Gosford City Council

**Re: Lot 519 DP729020 No 19 Brisbane Water Drive Koolewong
Gosford LGA – Proposed 50 Berth Mooring and Associated Car Parking
Part 3A Major Project Application MP10_0209
Request for Key Issues and Requirements**

I refer to your letter of 23 November 2010 and the following matters must be addressed in the Environmental Assessment.

Plan of: Proposed Marina for
Lot 519 in D.P. 729020

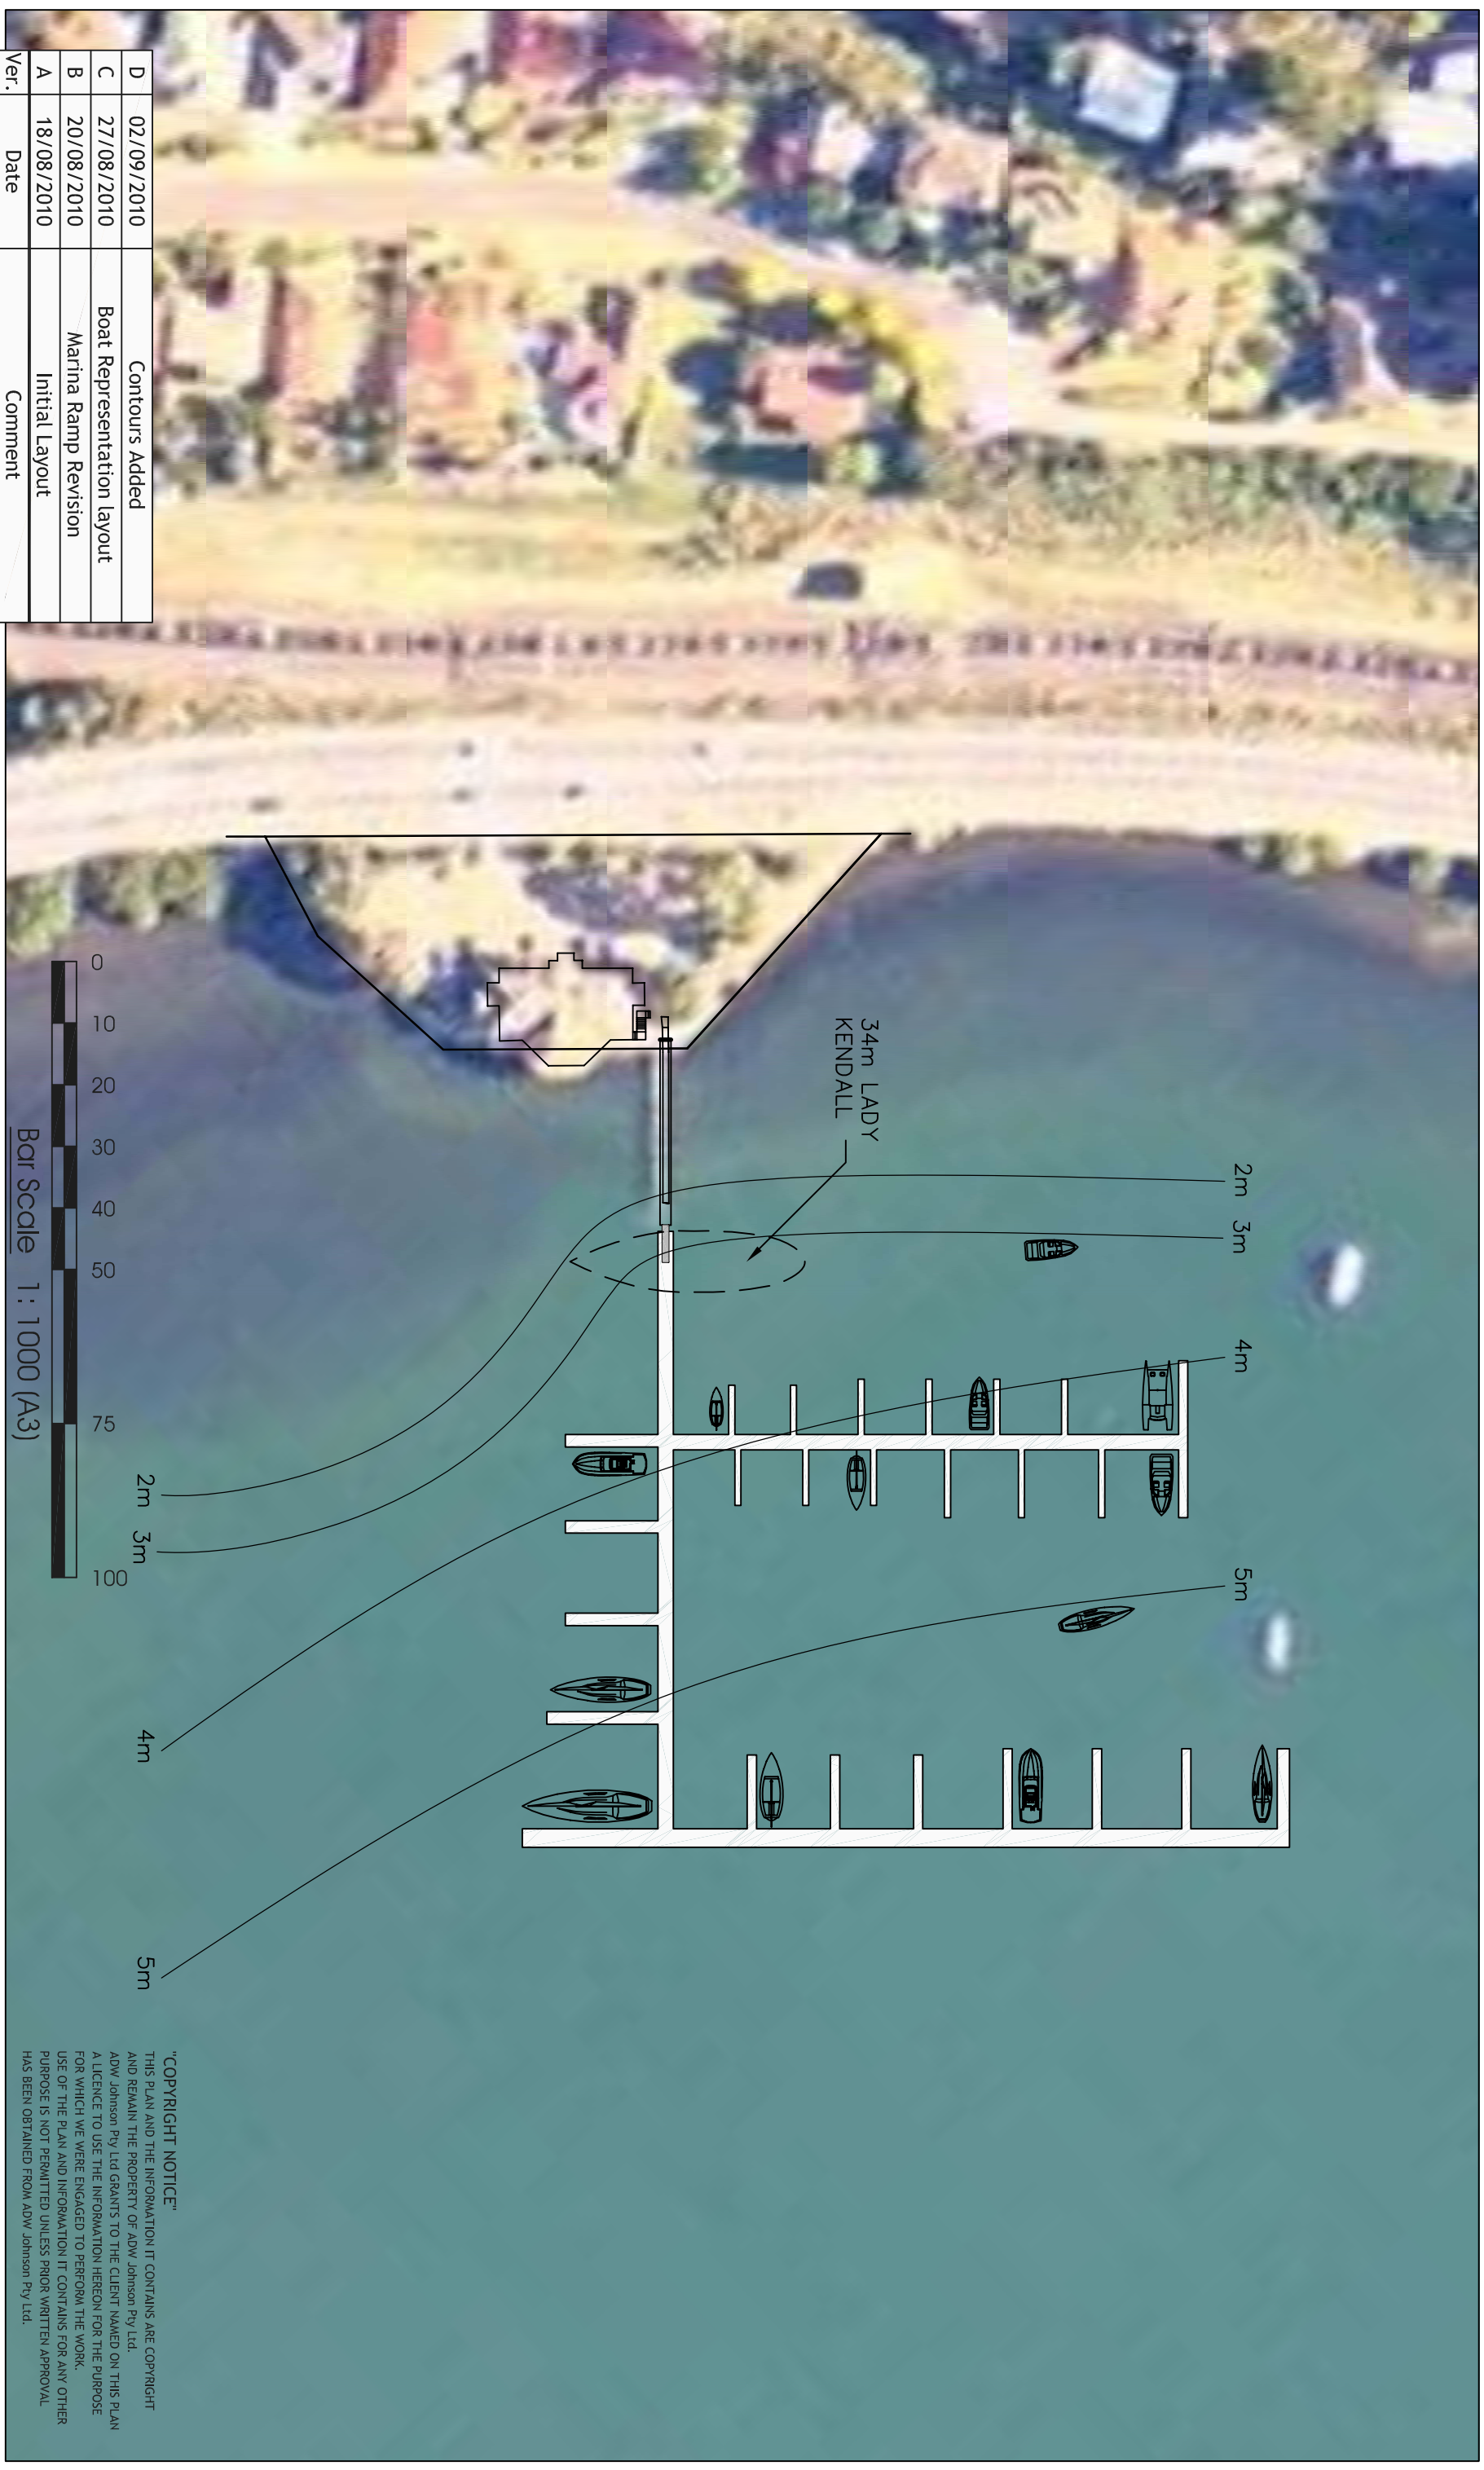
1. A 7 Part Test particularly for sea grasses and other aquatic impacts. The Sea Grass Habitat Mapping/Report prepared by Cardno Ecology shows a different proposed marina then that in the plans prepared by ADW Johnson. Additional aquatic survey may be required and an amended report.
Note: Council records indicate the endangered population of *Posidonia australis* is within close proximity to the proposal.
2. A Traffic Report prepared by a traffic engineer to address:-
 - (a) The traffic movements generated and the impact on traffic movements along Brisbane Water Drive. Traffic projections for the next ten (10) years (or as stipulated by the RTA) should be used.
 - (b) Whether the existing driveway is adequate and what works are needed to upgrade the driveway.
 - (c) Any works required on Brisbane Water Drive
 - (d) Car Parking demand
